I write to object to application A/176/17/PL.

Street Elevation (1:200)

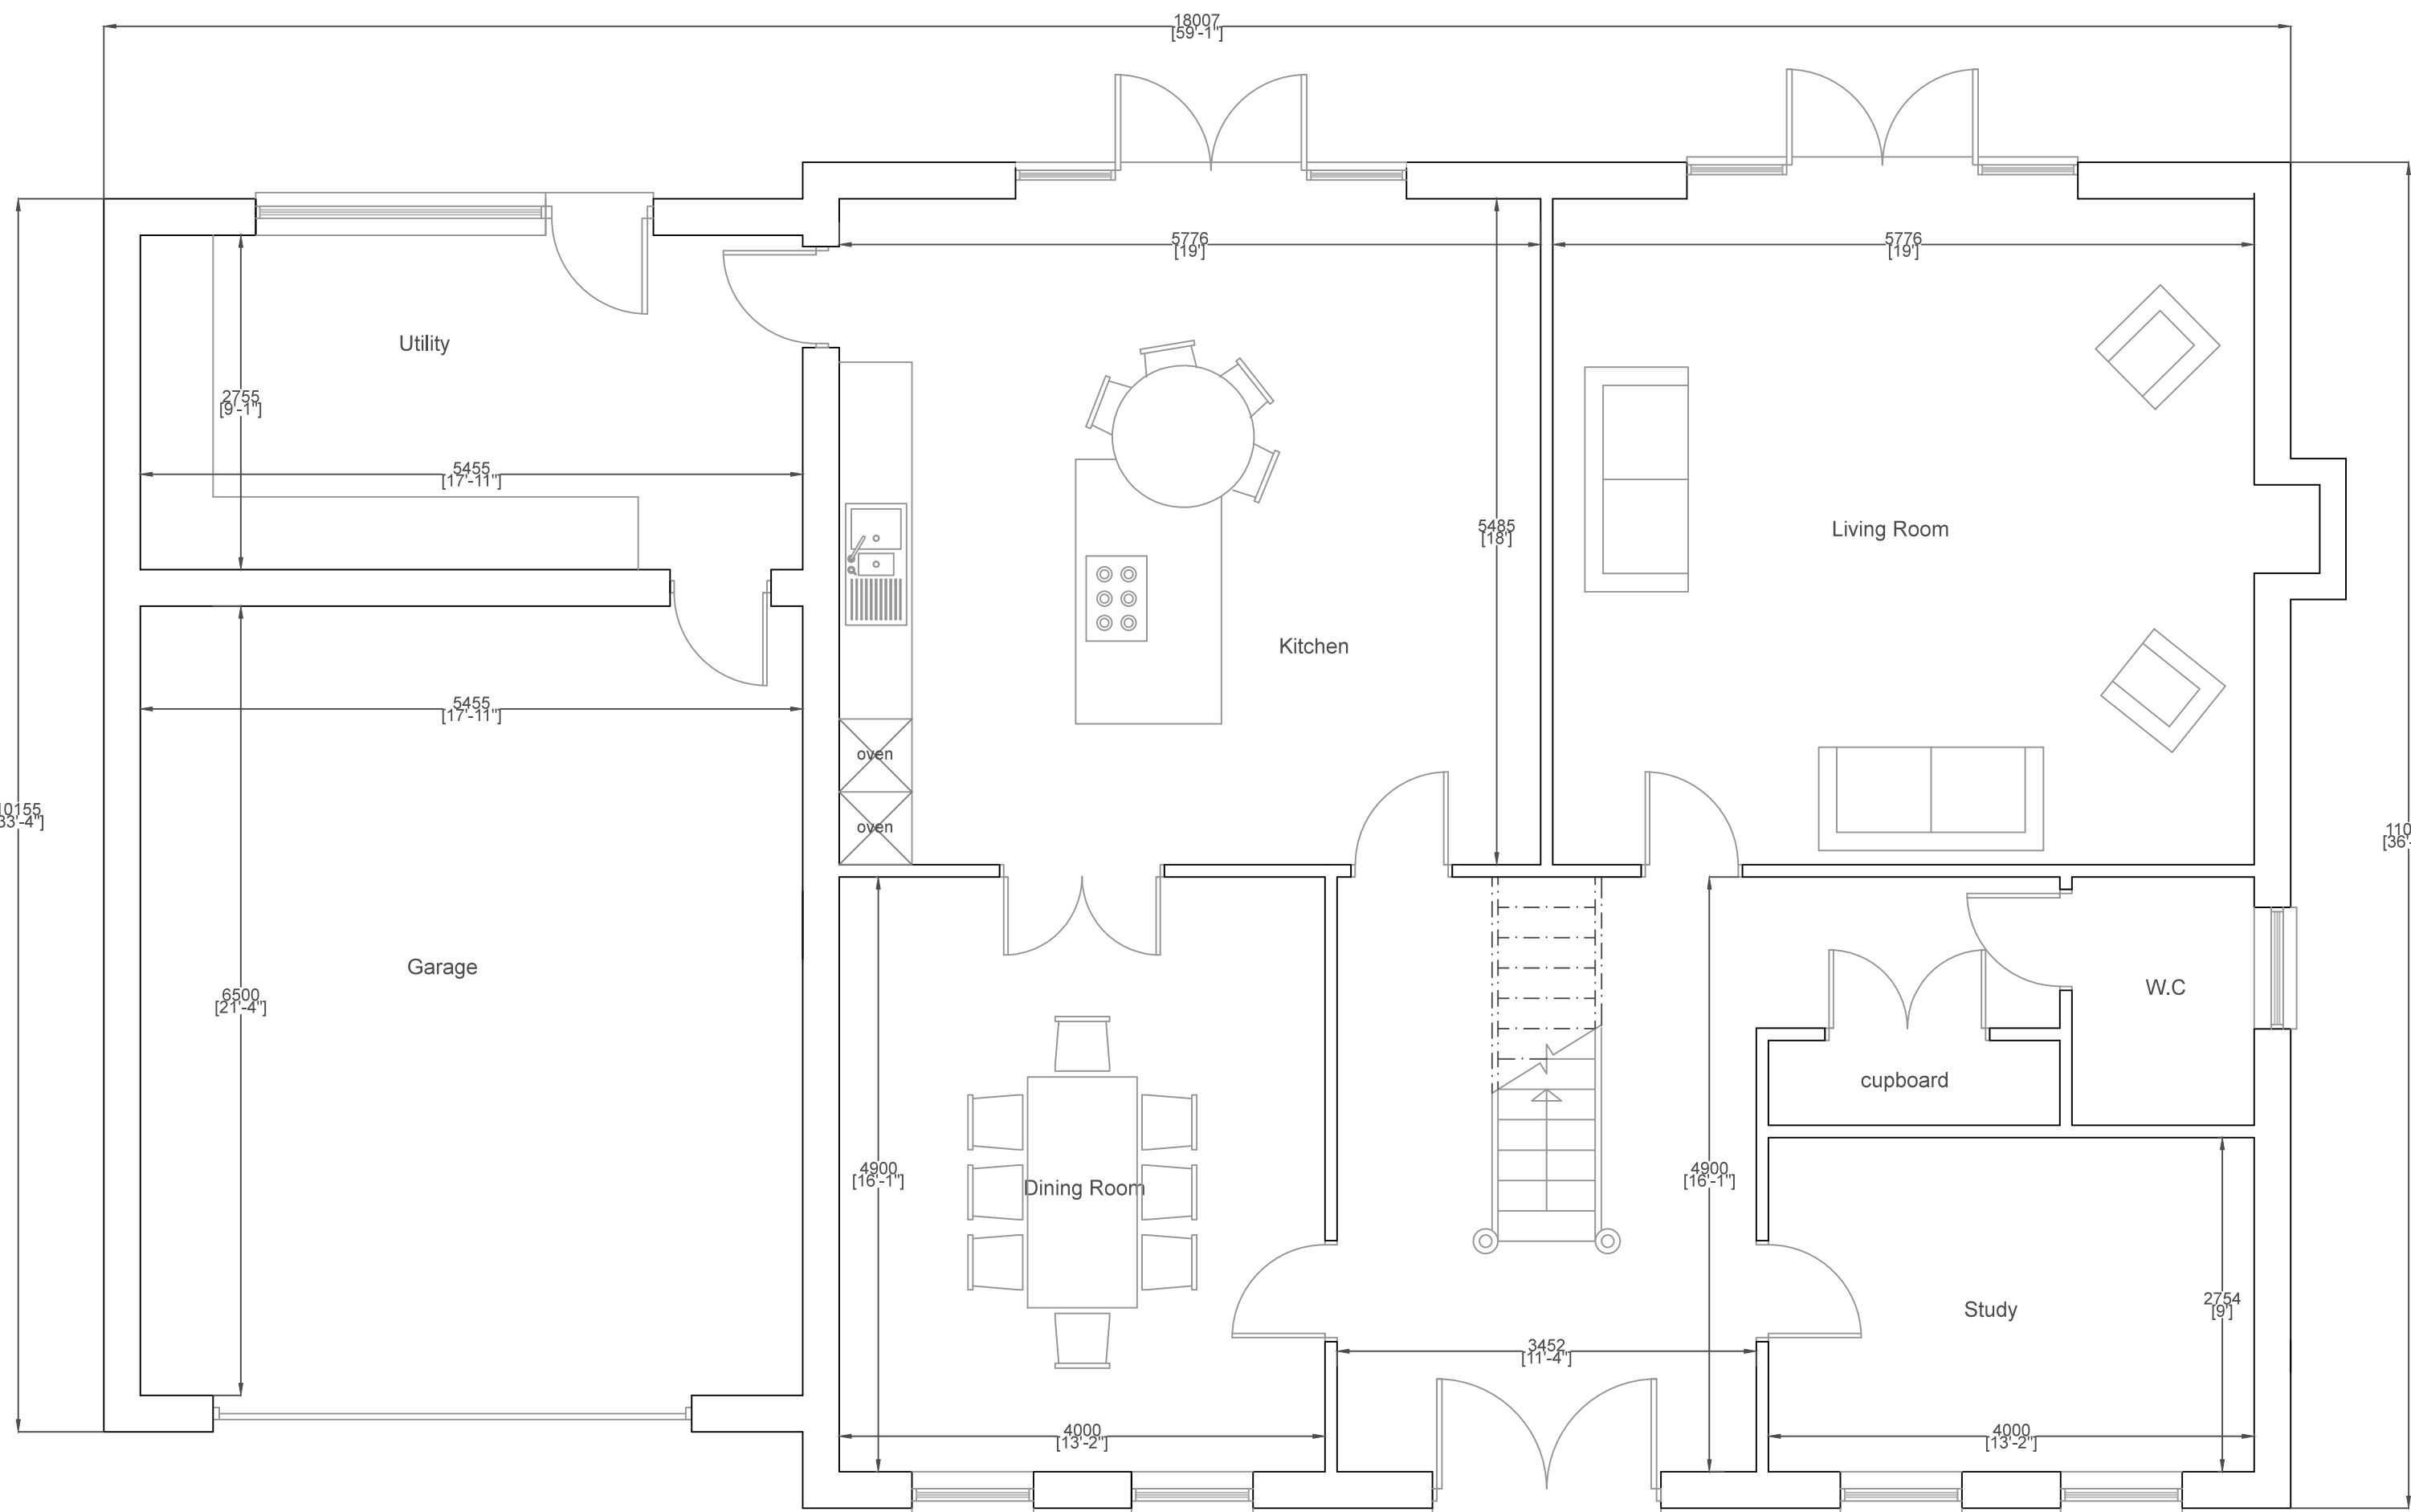
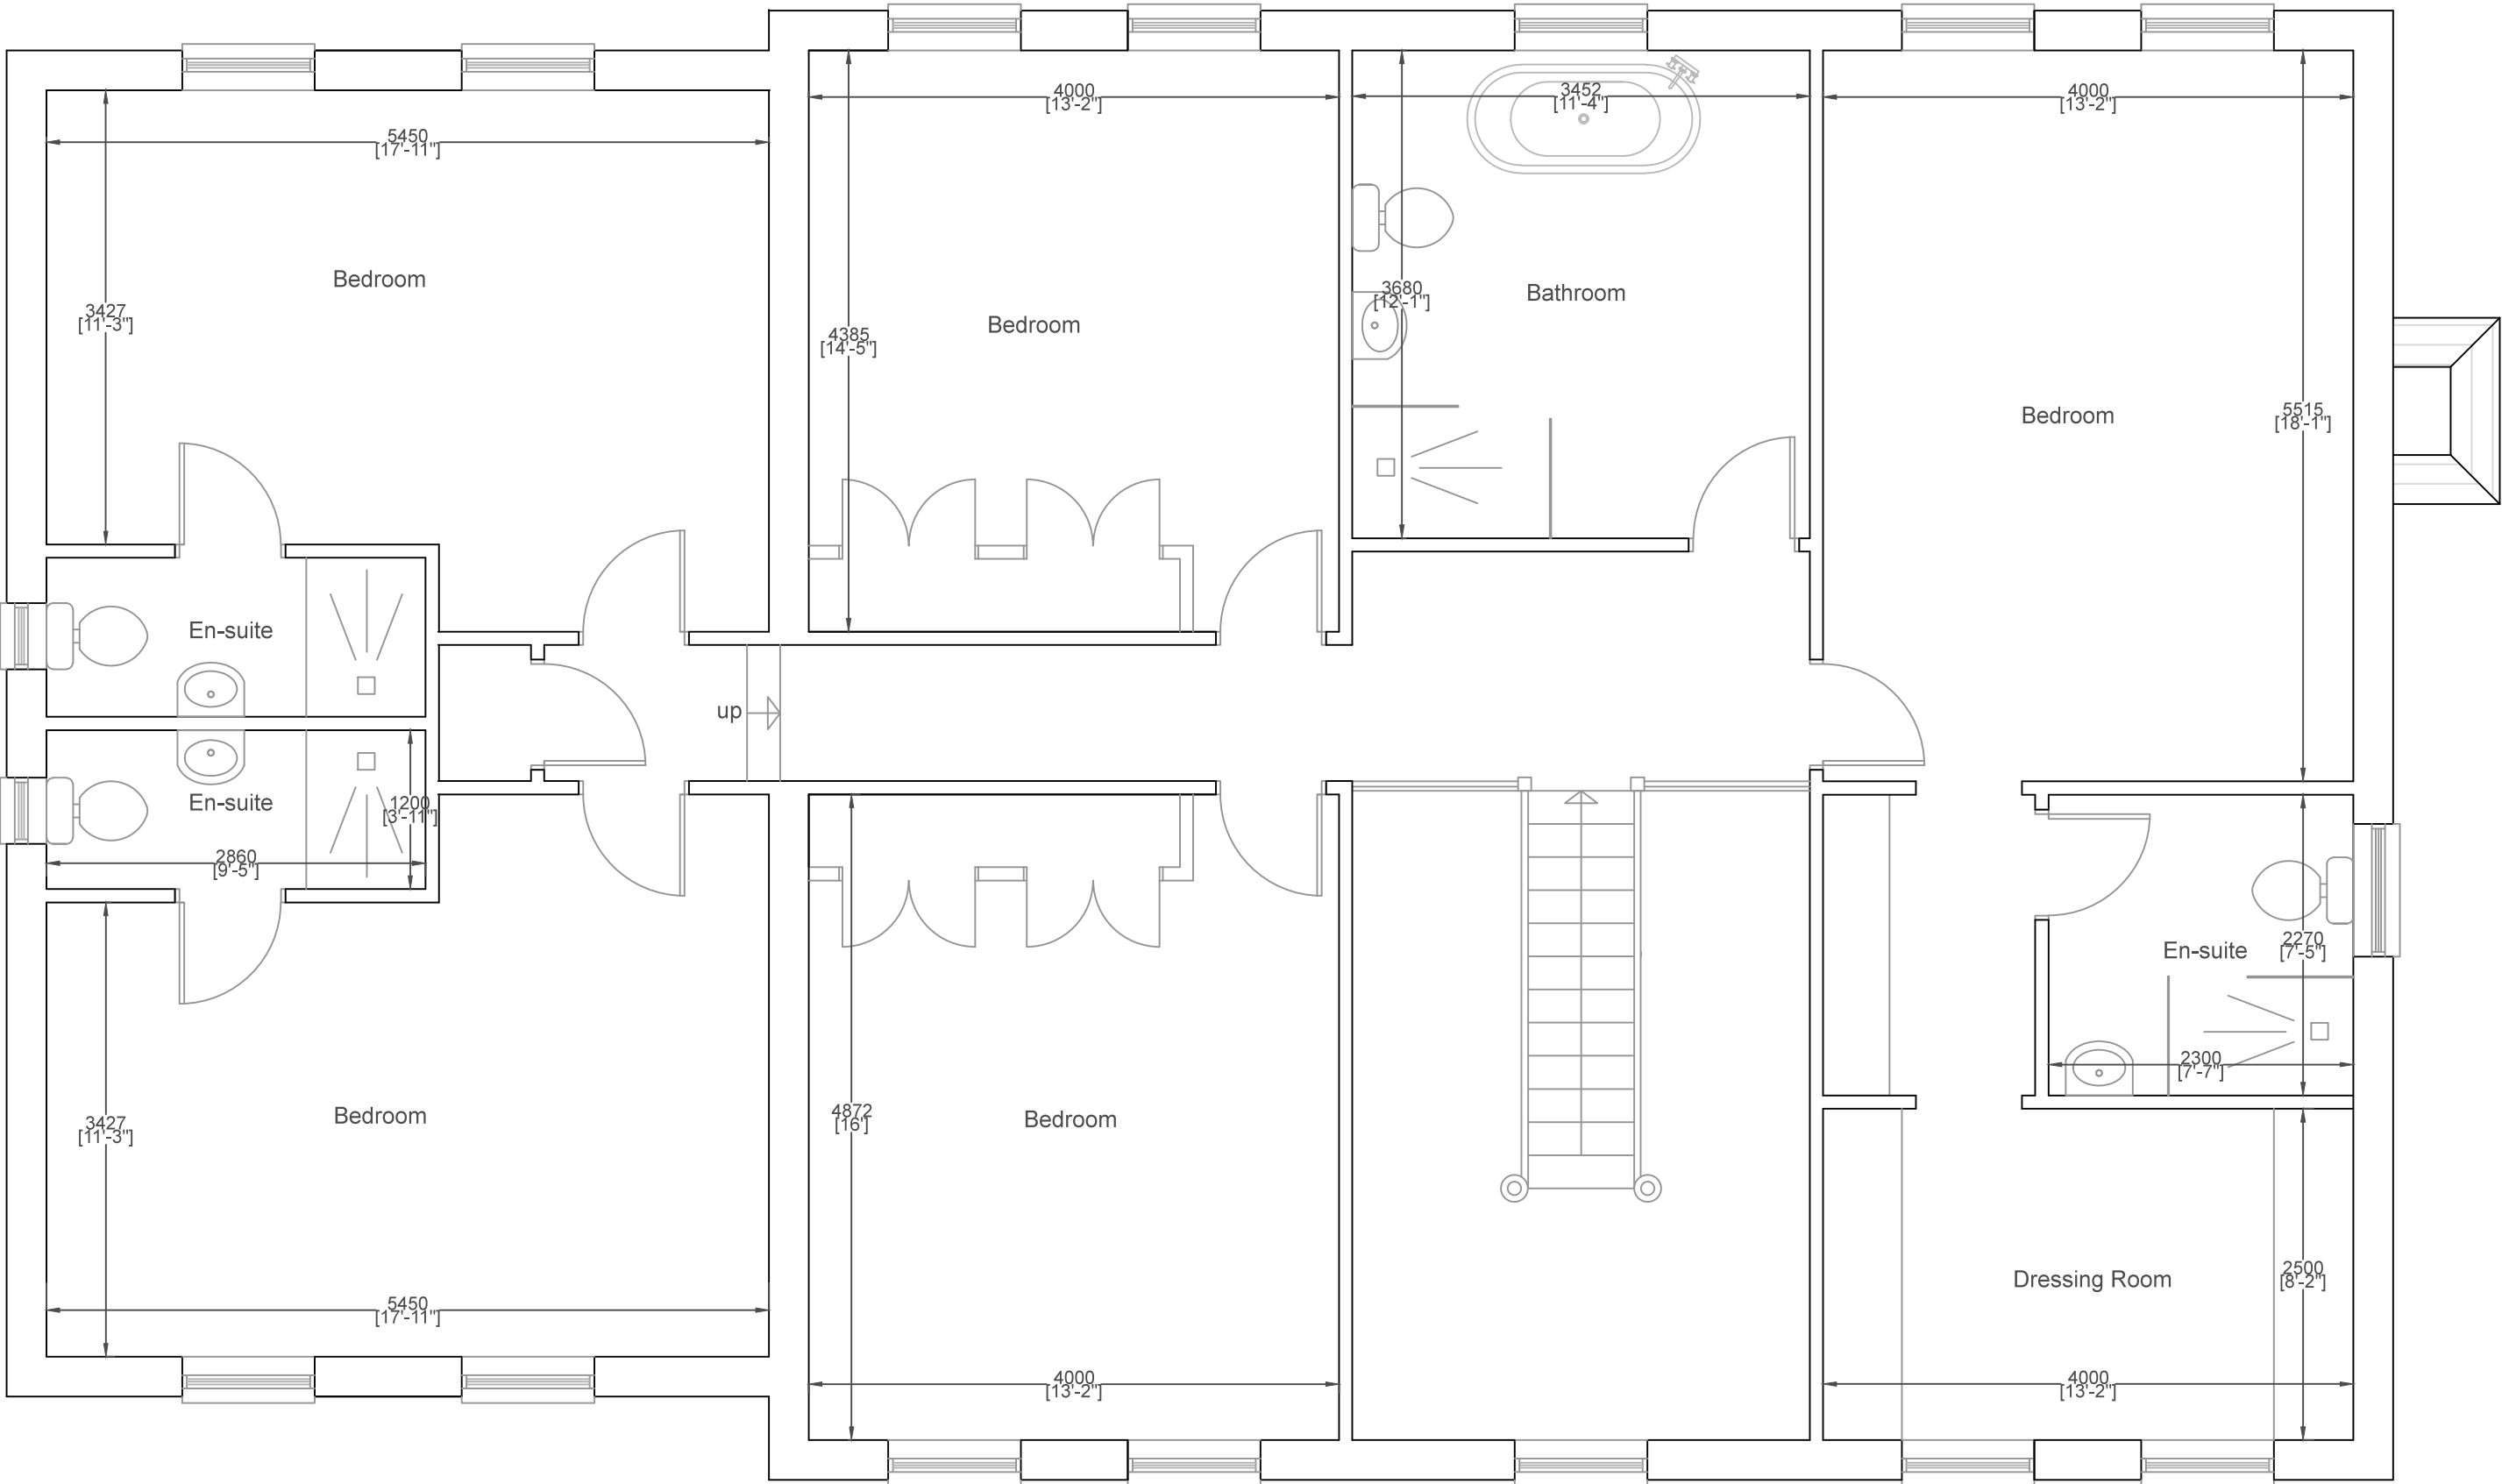
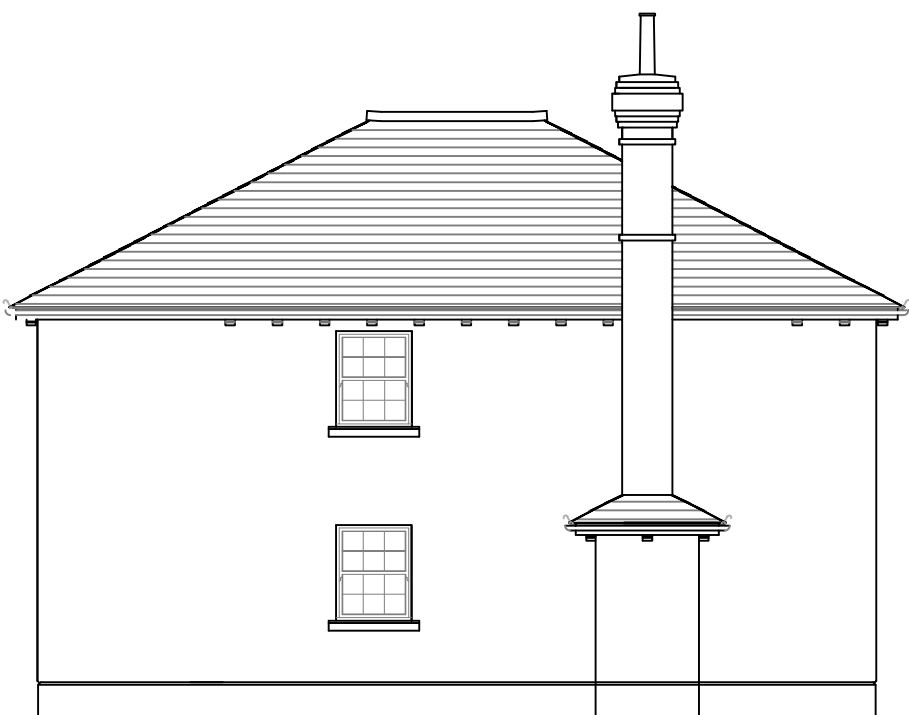
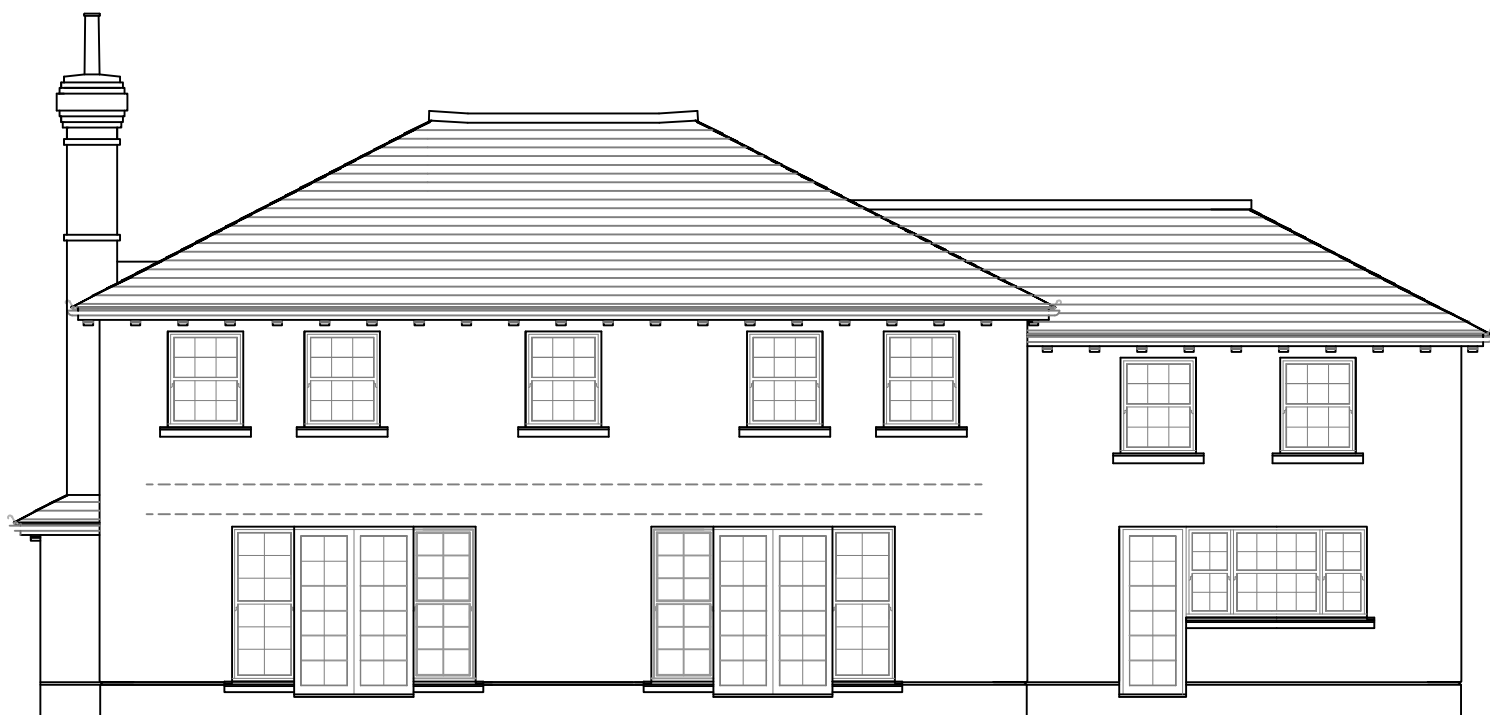
The open spaces in Ham Manor Way are of considerable beauty and any development would impact this unique land at the ninth and totally ruin the view of the protected countryside. The proposal will effect the environment and the amenities of local and neighbouring occupiers. For Angmering residents and occupiers the area in question is of community value, especially considering the thousands of people using the footpath for access and recreation and enjoyment of the Historic Parkland which will be lost to all if developed.
